PERMANENT EASEMENT

Project # 762382

Re: Menaul Site – Tract A, Zuni Addition, Drainage Plan
Engineer's Stamp dated 02-08-13 For The Offsite Drainage Exhibit and 3-05-13
For The Supplemental Information (H19/D055)

RE: **Menaul / Prospect Retail Center - 7402 Menaul NE**
Grading & Drainage Plan for Preliminary Plat

DRAINAGE ANALYSIS

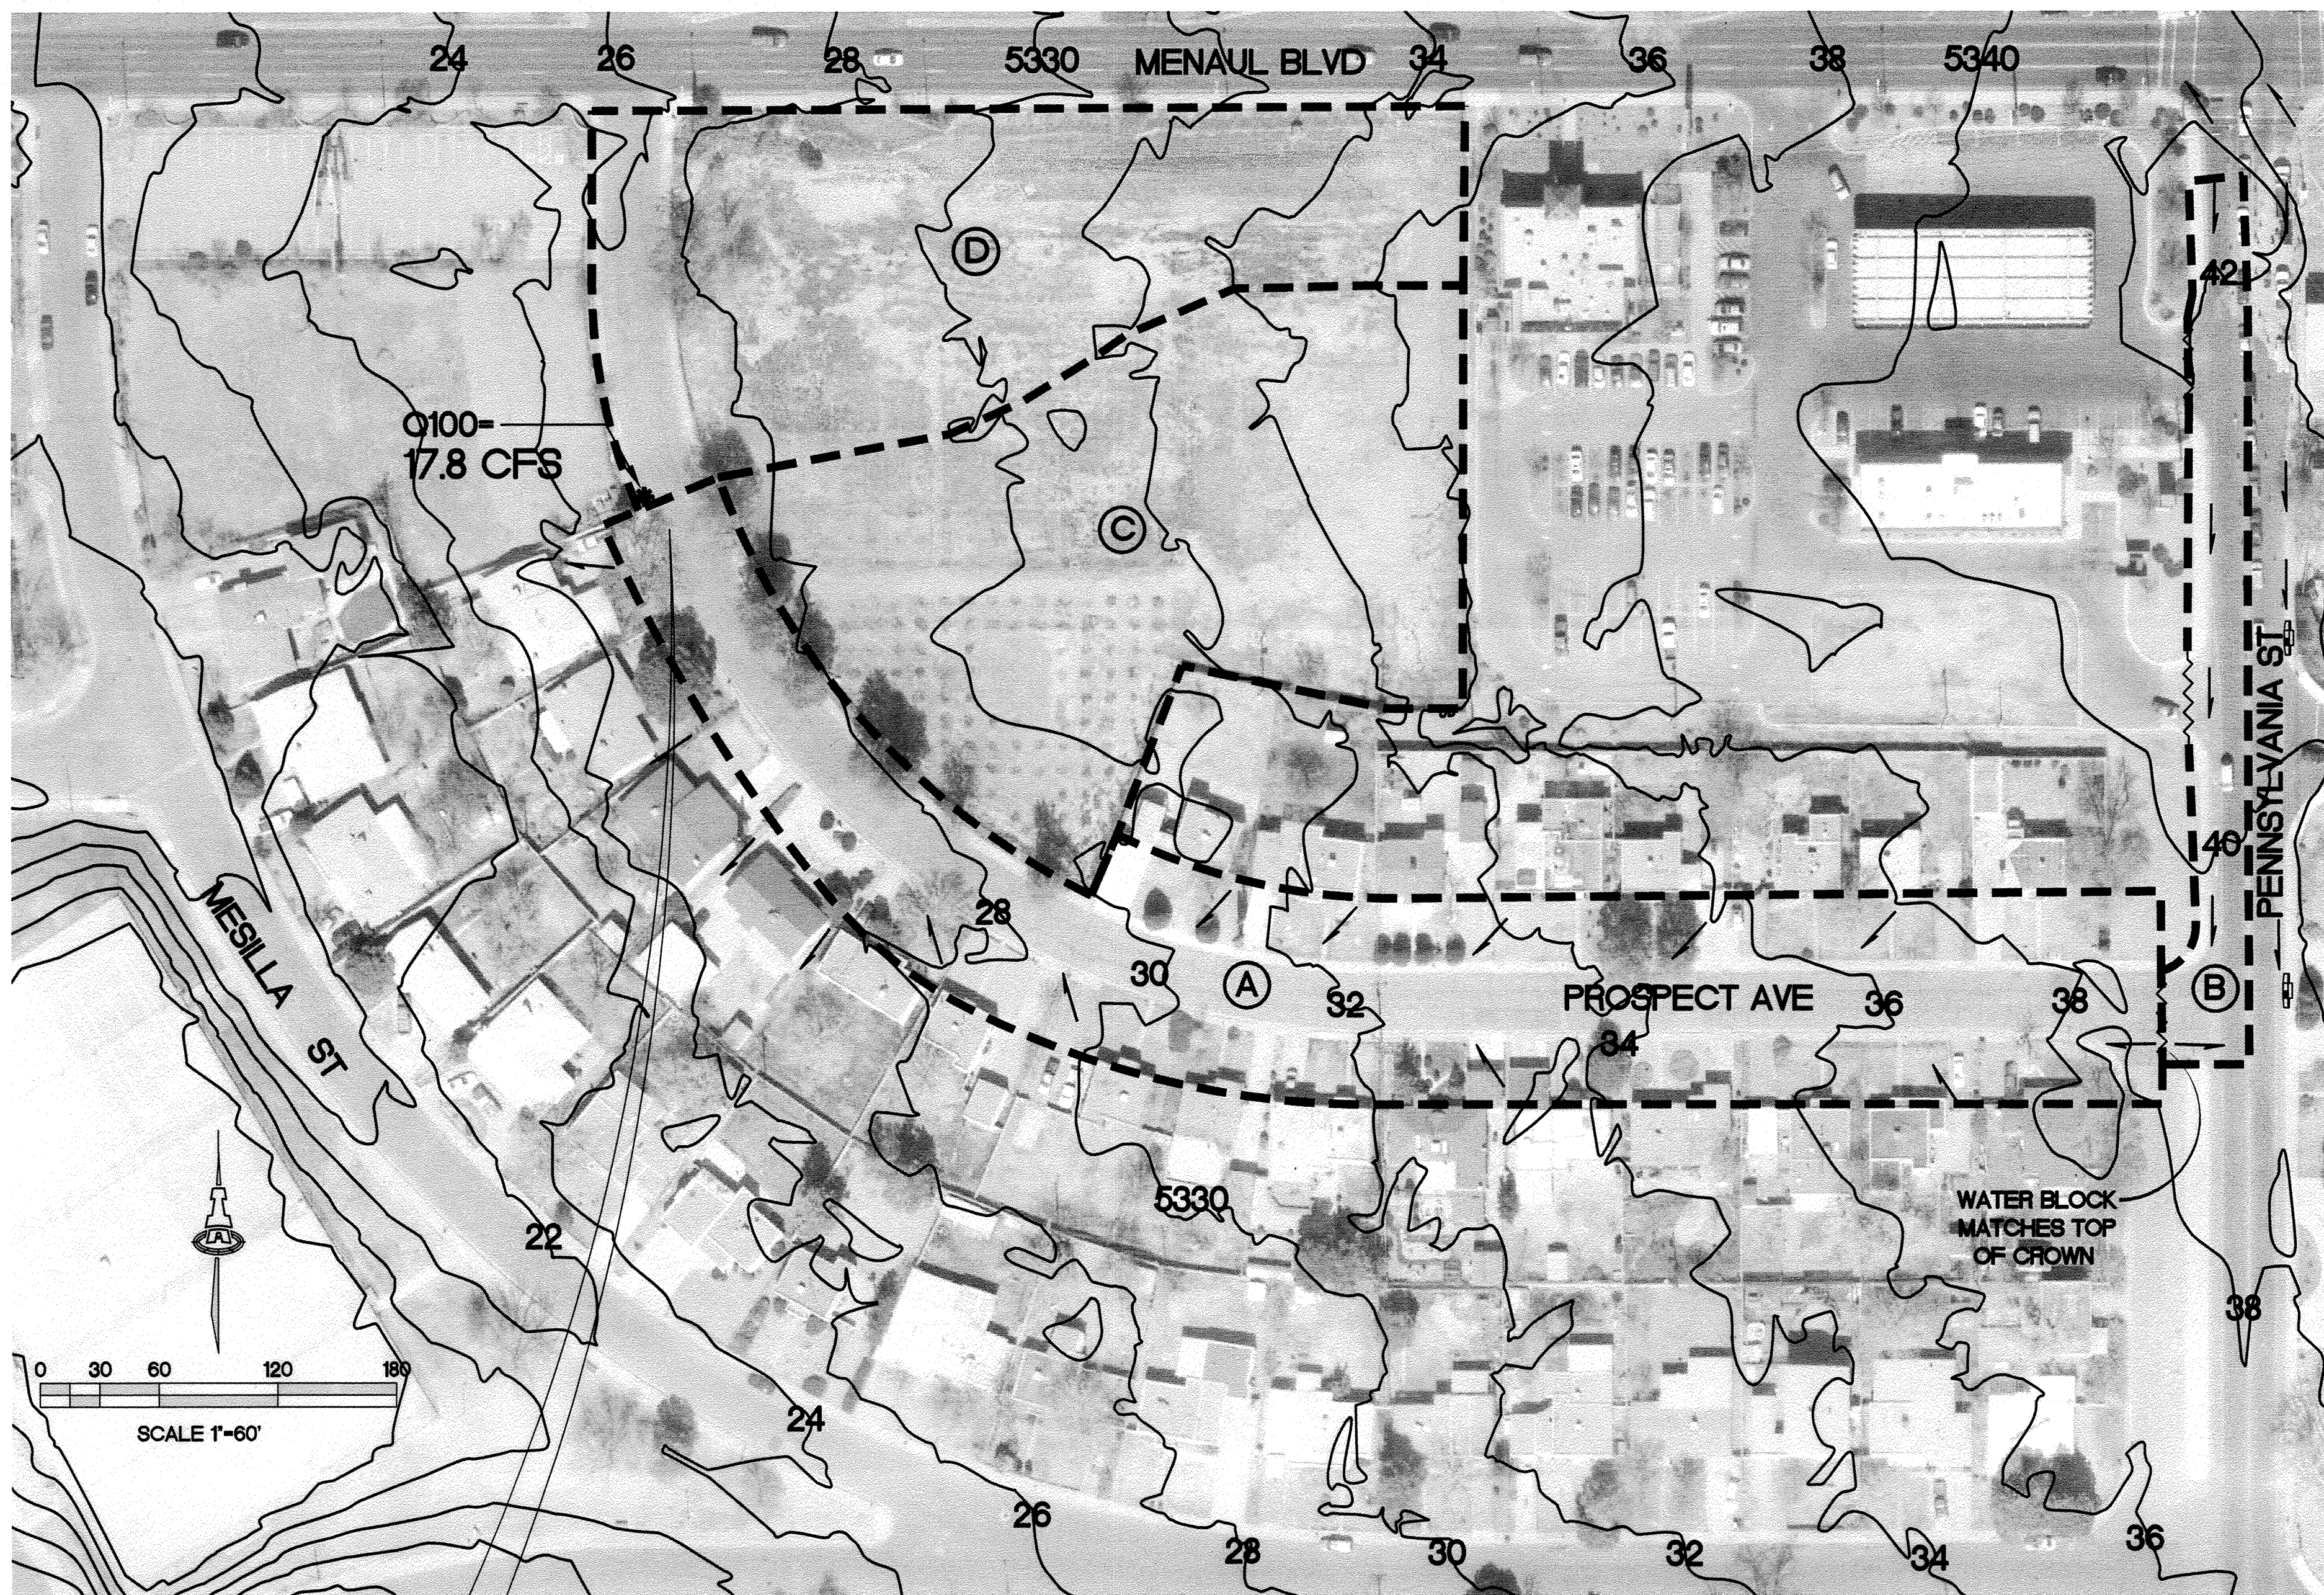
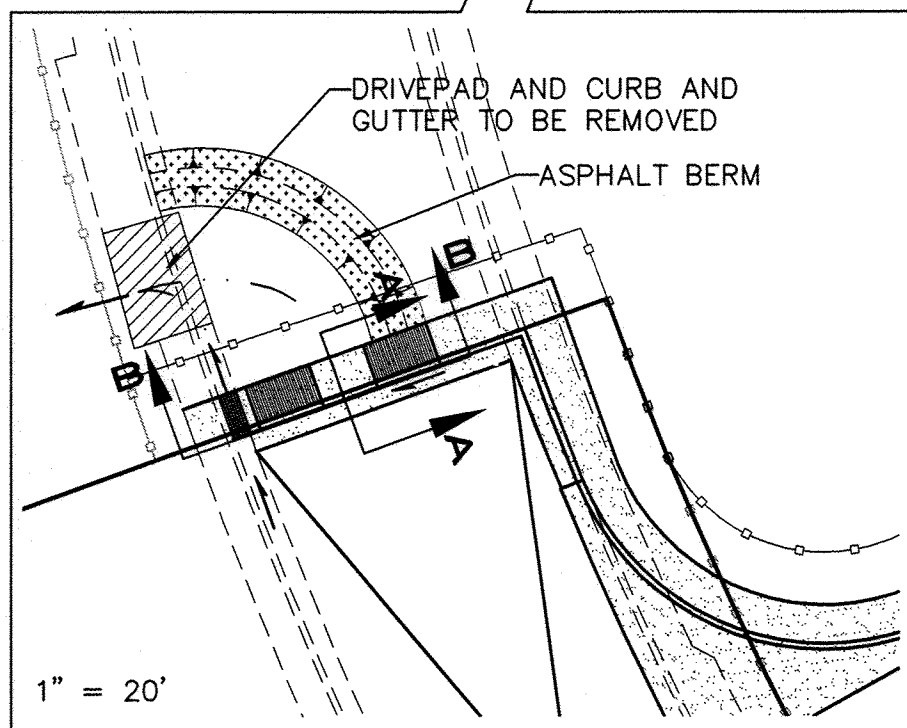
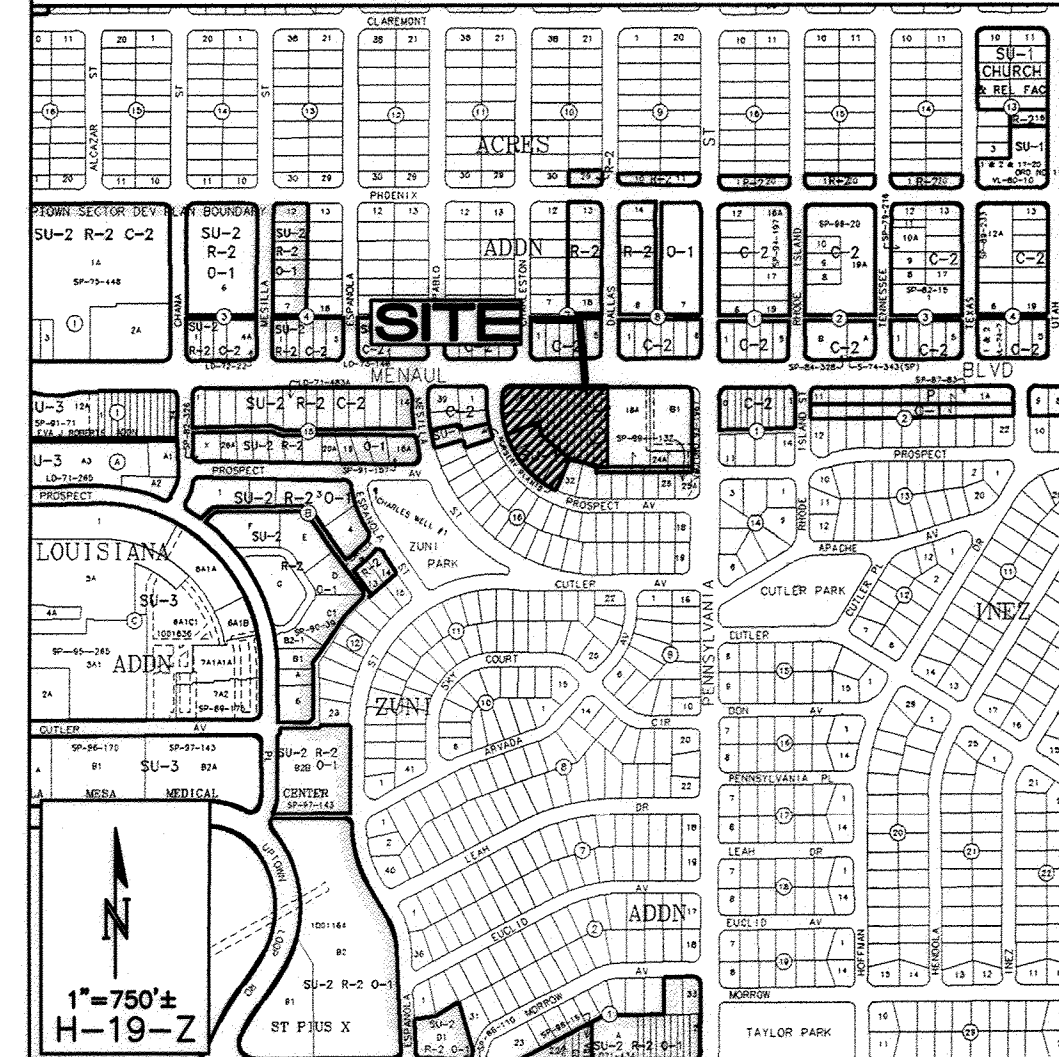
- The runoff from the north side of lots 7437 through 7509 Prospect Ave. appears to enter Basin C. Please include these flows in your calculations.
- A full grading and drainage plan will be required.
- Mesilla St. should be analyzed to assure additional runoff from this project will not have an adverse impact on the street flow capacity.
- Provide an Erosion Sediment Control Plan.
